Appendix 8 – Consultation Responses - Proposed Changes

Drax Bioenergy with Carbon Capture and Storage

Changes Application Report

Document Reference Number: 8.5.3.8

PROJECT No: 70072063	DRAWING No: 70072063-FCA-1	REV: A
--------------------------------	-------------------------------	------------------

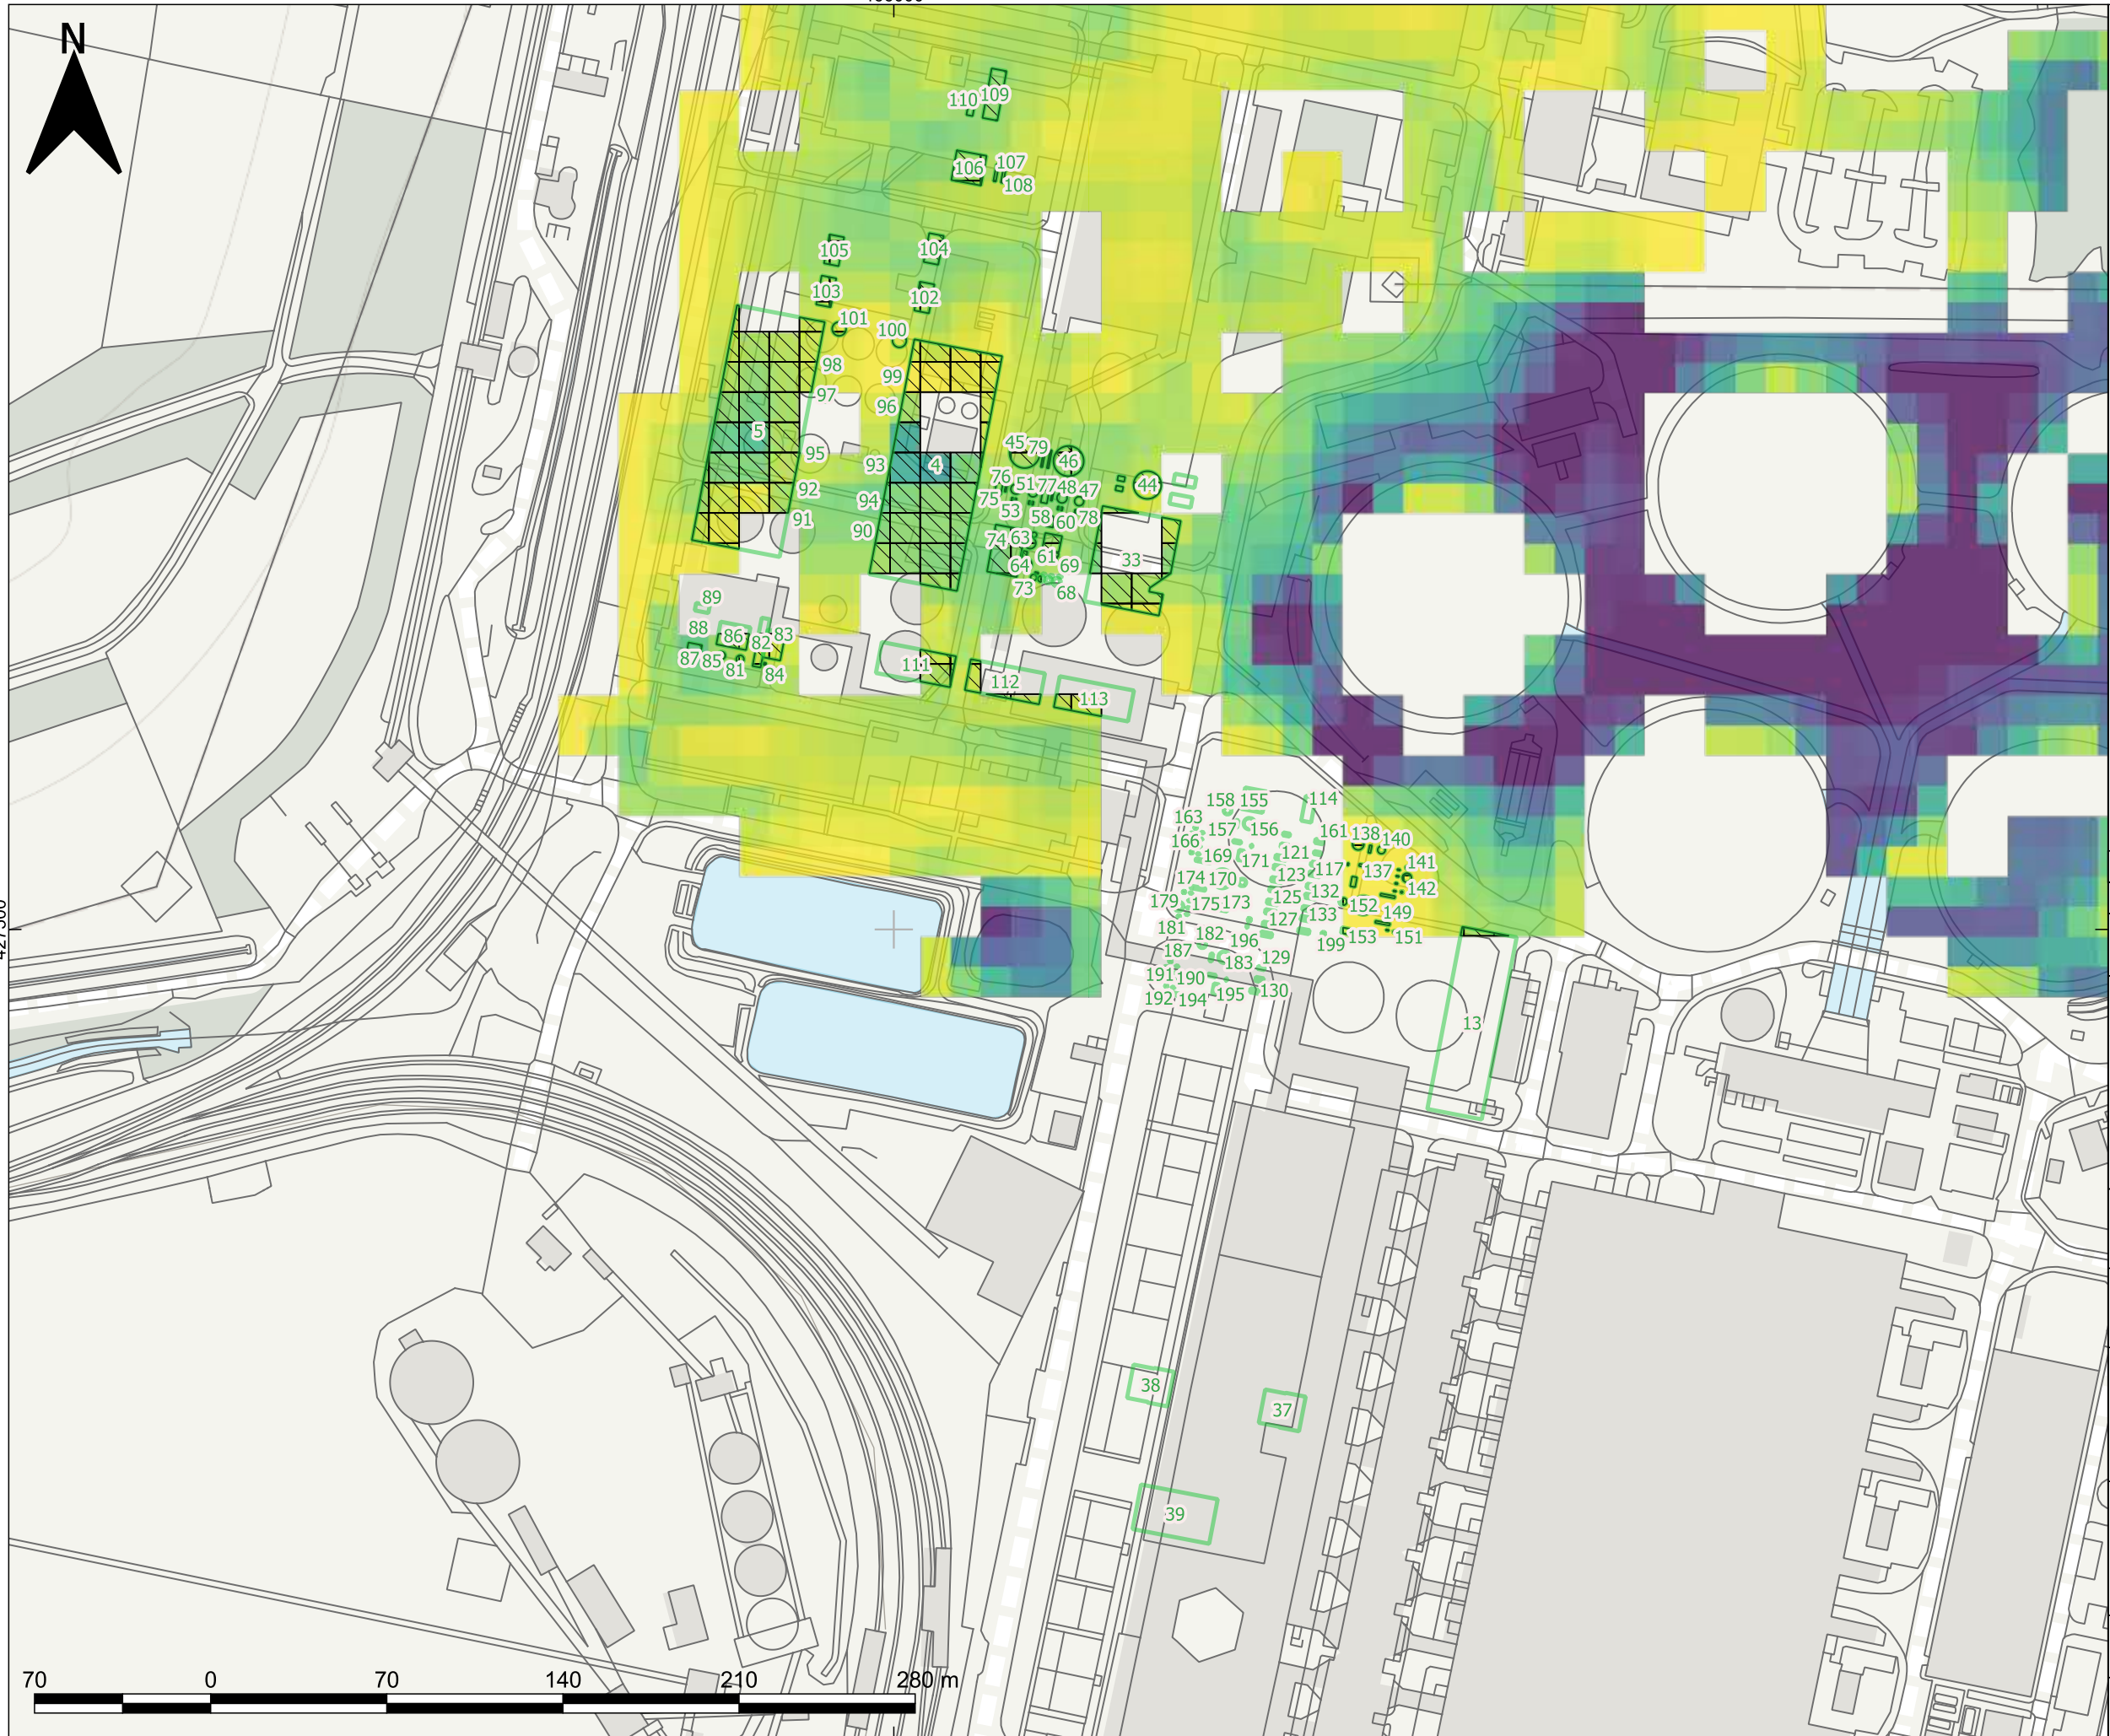
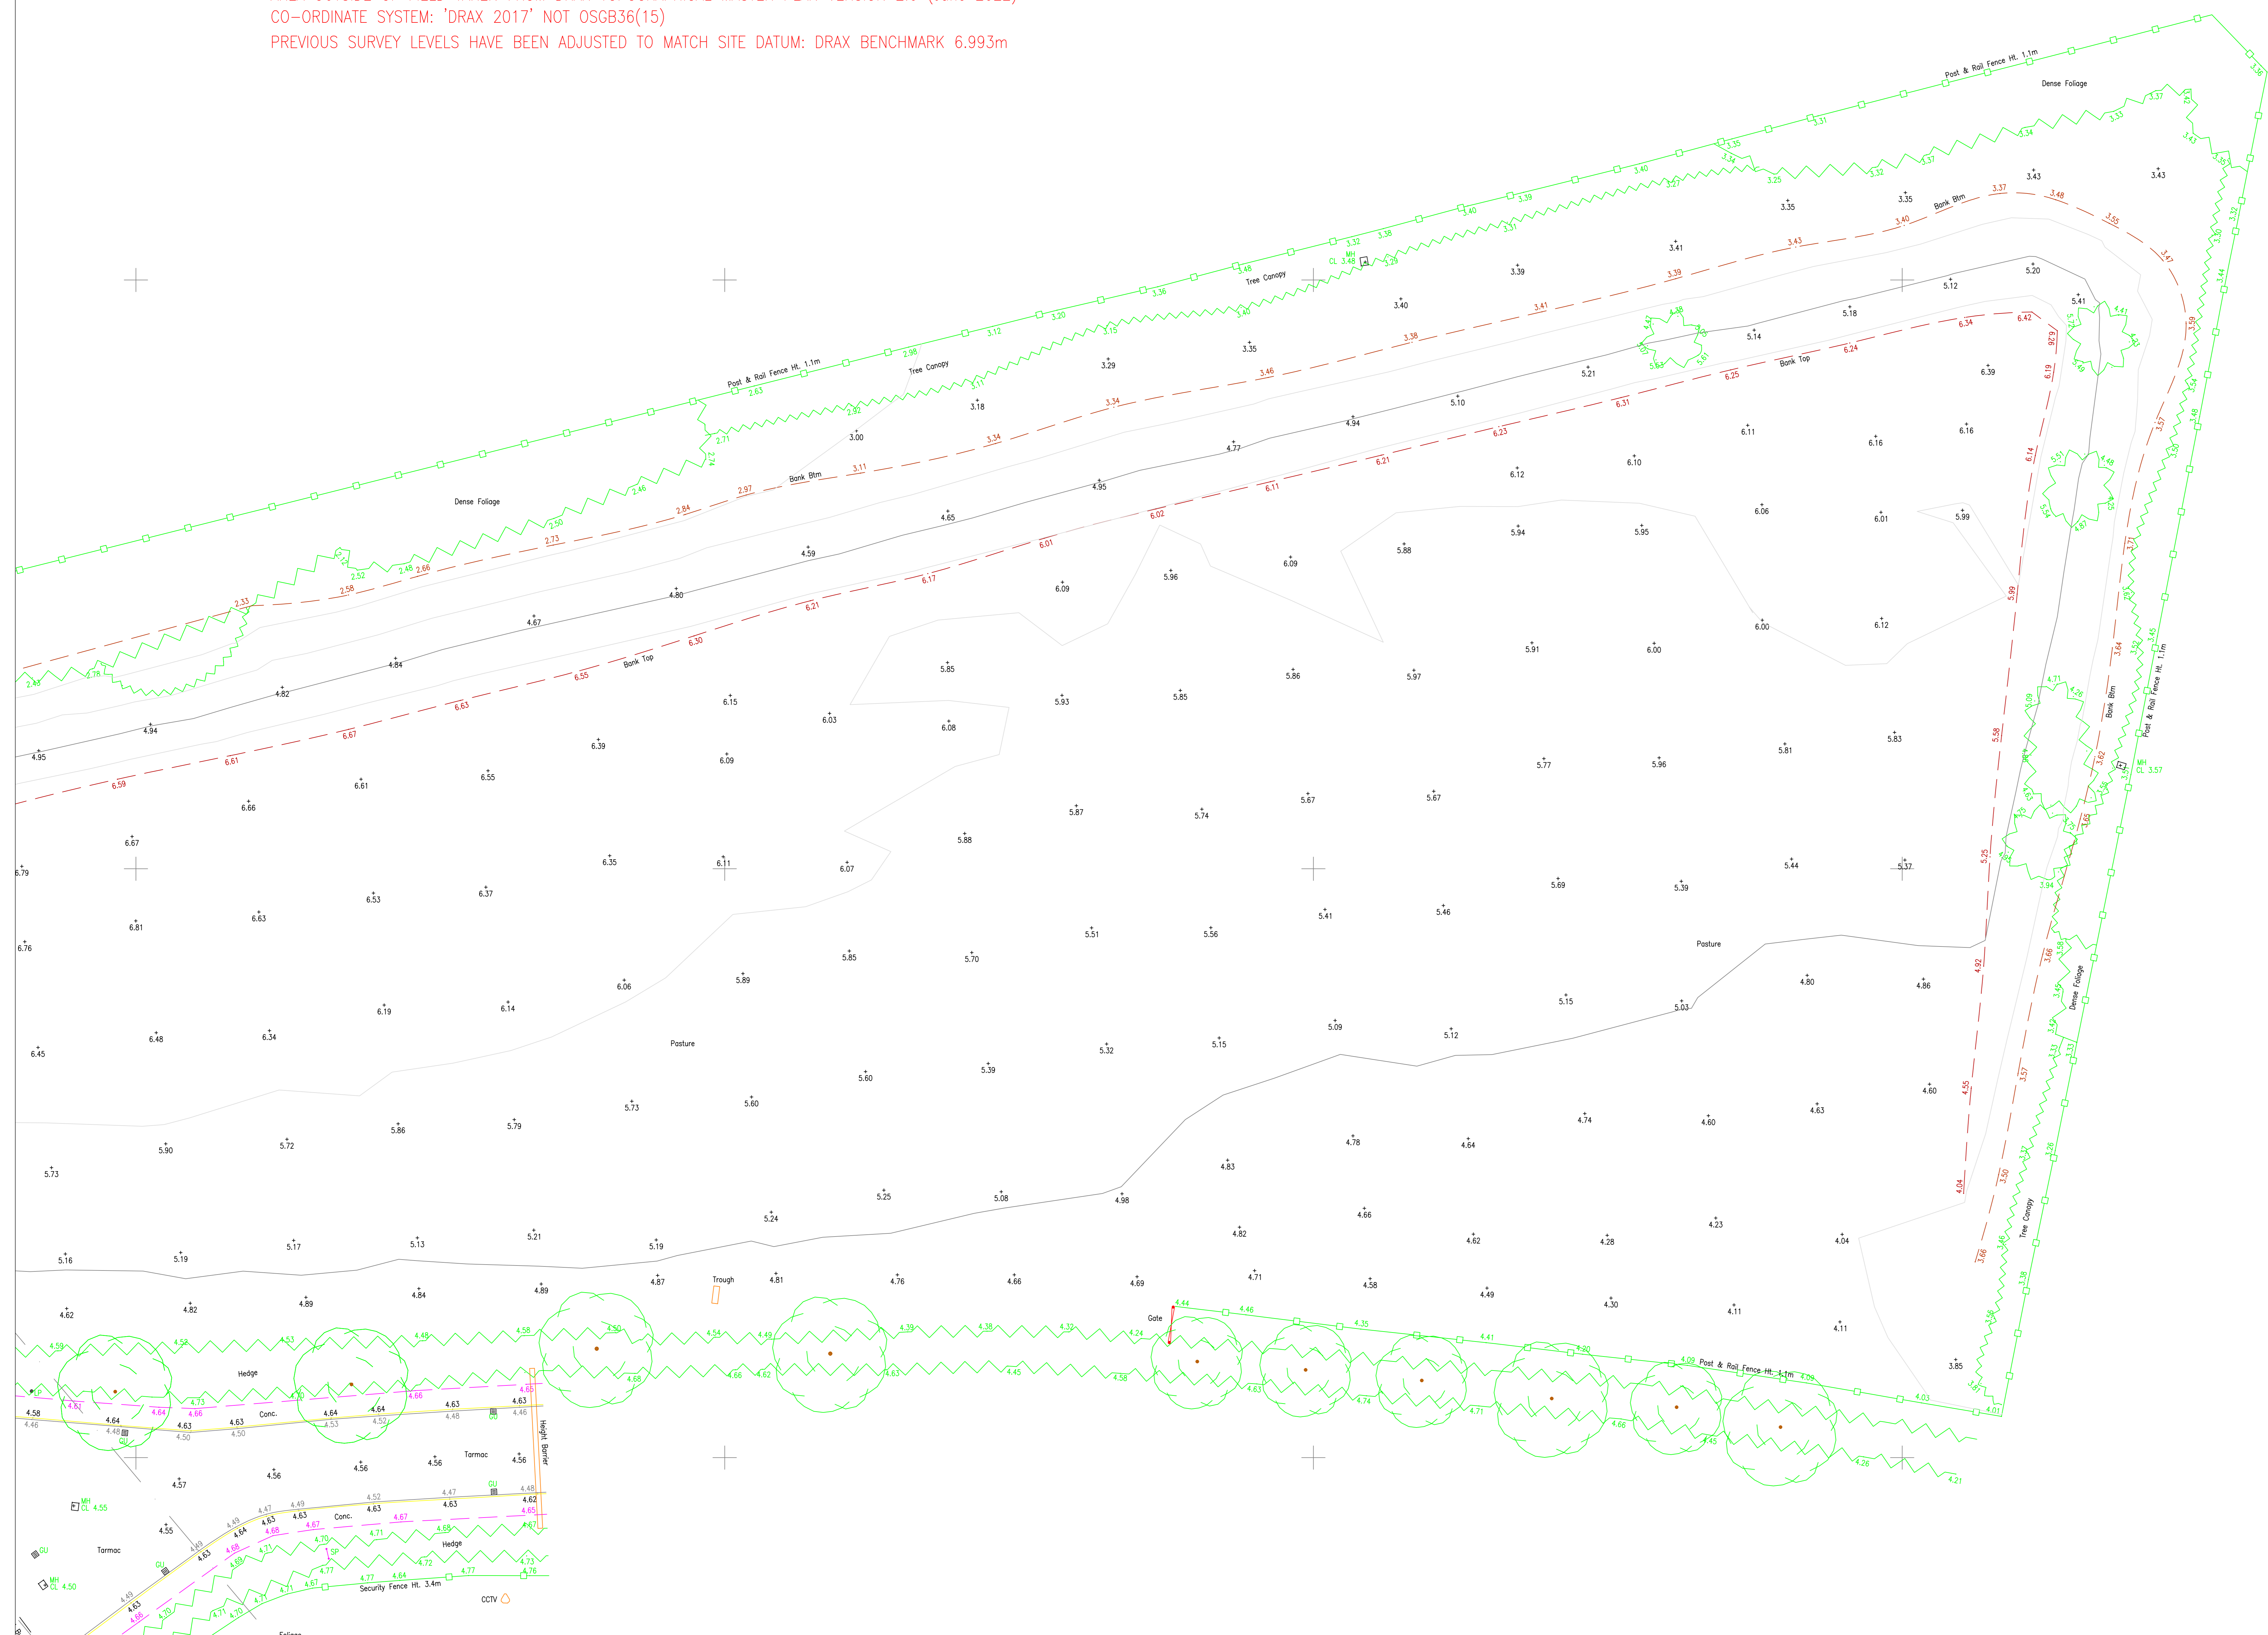
Y6	Natural England	The land subject to PC-01 Replacement floodplain compensation area (FCA) is mapped as Provisional ALC Grade 2.	The Applicant notes the comment. An ALC survey was completed for PC-01 in November 2022 which classified the land as Grade 3b (non-BMV).
Y7	Natural England	The FCA is proposed to undergo engineering operations to lower the ground level, which requires the following considerations: The ground lowering required for the FCA may increase the extent of the 1 in 100 and 1 in	The Applicant notes the comment. To inform consideration of this, a ground investigation comprising six trial pits was undertaken on 18 October 2022 to determine ground conditions (please see 8.5.3.1). The ground investigation reported similar ground conditions across

<p>200 year flood risk. The potential impact of this increased flooding regarding ALC grade needs to be considered in the assessment as this could result in a loss of Best and Most Versatile (BMV) agricultural land.</p> <p>Flood extent, duration, frequency and timing may give rise to soil management problems after the event, depending upon the types of soil present. ALC guidance for the assessment of flood risk (MAFF, 1988) says 'The after-effects of inundation depend in part on soil –type and will generally be more serious on impermeable soils, which remain saturated for longer periods than impermeable soils' and also states that 'Further downgrading may be justified where flooding affects soils of low permeability'.</p> <p>a. The excavated soil is proposed to be placed on the southern area of the field. This will alter the soil profile of not only the FCA but also the receiving land. This may impact the ALC Grade following construction works of both the donor and receptor site. The potential impact of these changes to the soil profile regarding ALC grade needs to be</p>	<p>the FCA area. Made Ground was identified at each discrete location, underlain locally by superficial deposits of Alluvium, and widely by laminated clay of the Hemingbrough Glaciolacustrine Formation. A review of historical mapping indicated the FCA was historically within an area indicated to be liable to flooding. Mapping indicates the Site topographical profile was created in late 1980s or early 1990s associated with the expansion of Drax Power Station with the placement of Made Ground materials, likely from the area adjacent to the west.</p> <p>An ALC survey undertaken in November 2022 classified the soils within the proposed FCA as Grade 3b (non BMV). A Soil Handling Management Plan will be produced (as already committed to in Ref ID GC2 in the REAC (AS-027)) which will detail clear guidance on the methods of recovering, storing and reinstating the soils whilst minimising a loss in quality and function during construction.</p> <p>With regard to the extent, duration, frequency and timing of any flooding is that the FCA is proposed to address the impacts of climate change. It would be required should the Environment Agency not maintain the flood defences to keep pace with the impacts of climate change. In which case the FCA would be expected to be used for the 1 in 100 year flood event.</p> <p>The FCA is currently used for sheep grazing, however upon completion of the works, the FCA would be reinstated as grassland and form part of the updated</p>

<p>considered in the assessment as this could result in a loss of Best and Most Versatile (BMV) agricultural land at both the receptor and receiver sites.</p>	<p>Outline Landscape and Biodiversity Strategy removing it from agricultural use. This would represent a permanent loss of approximately 2.2 hectares of non BMV land. However removing land from agricultural use and including it within the Landscape and Biodiversity Strategy presents opportunities for improved soil health (improved soil structure, carbon sequestration, soil biodiversity) as the land would not be exposed to degradation from ploughing, pesticides and herbicides and compaction from farm vehicles.</p>
Y8	Natural England	<p>The land subject to PC-02 Relocation of OHL; A645/A614 Rawcliffe Road roundabout is mapped as Provisional ALC Grade 2; whilst A614 Rawcliffe Road/Airmyn Road roundabout has post-1988 ALC information available (Agricultural Land Classification detailed Post 1988 ALC survey, Airmyn, New Wood (Goole Hook LP Site 12) - ALCL03791 (naturalengland.org.uk)).</p> <p>Where detailed data is not available, a detailed ALC and soil survey should be undertaken to inform the baseline and inform soil handling and suitability for re-use, including depth of topsoil strip.</p>	<p>The Applicant notes the comment.</p> <p>For the A614 Rawcliffe Road/Airmyn Road roundabout the estimated area of potentially impacted Grade 2 ALC land is 1600m². For the A645/A614 Rawcliffe Road the estimated area of potentially impacted Grade 2 ALC land is 3,250m².</p> <p>The total estimated area of BMV agricultural soils which may be impacted by the proposed works is 4,850m² (approximately 0.5ha).</p> <p>Works are short term and temporary (estimated at 10 days of work per line) with the land proposed to remain in agricultural use with no loss of BMV. A Soil Handling Management Plan would be produced (as already committed to in Ref ID GC2 in the REAC (AS-027)) which would detail clear guidance on the methods of recovering, storing and reinstating the soils whilst minimising a loss in quality and function during construction.</p>
